Our Ref: 20/00967/FUL  
Your Ref: 31 Highland Road - rear  
exten...

21st December 2020

LOCATION: 31 Highland Road, Southsea, PO4 9DA, ,

PROPOSAL: Construction of single storey extension to rear, velux windows to front and rear roof slopes, new shop frontage, french doors to first floor and glazed balcony. **(20/00967/FUL)**

11 SIDE ELEVATION
EXISTING

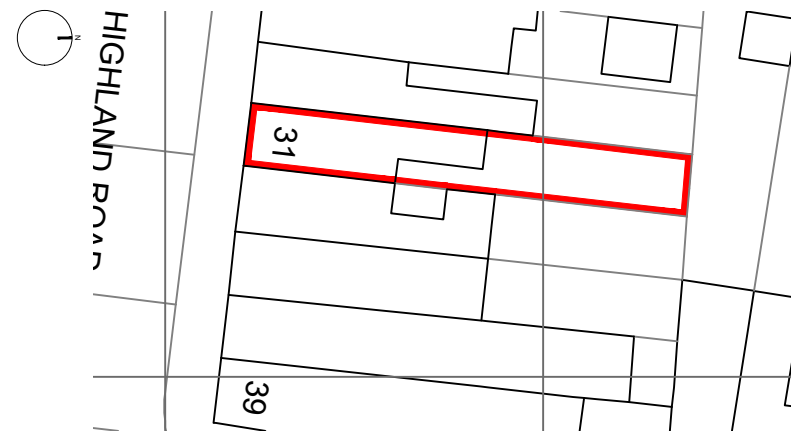
- 1) The second side elevation plan is required. Please update.
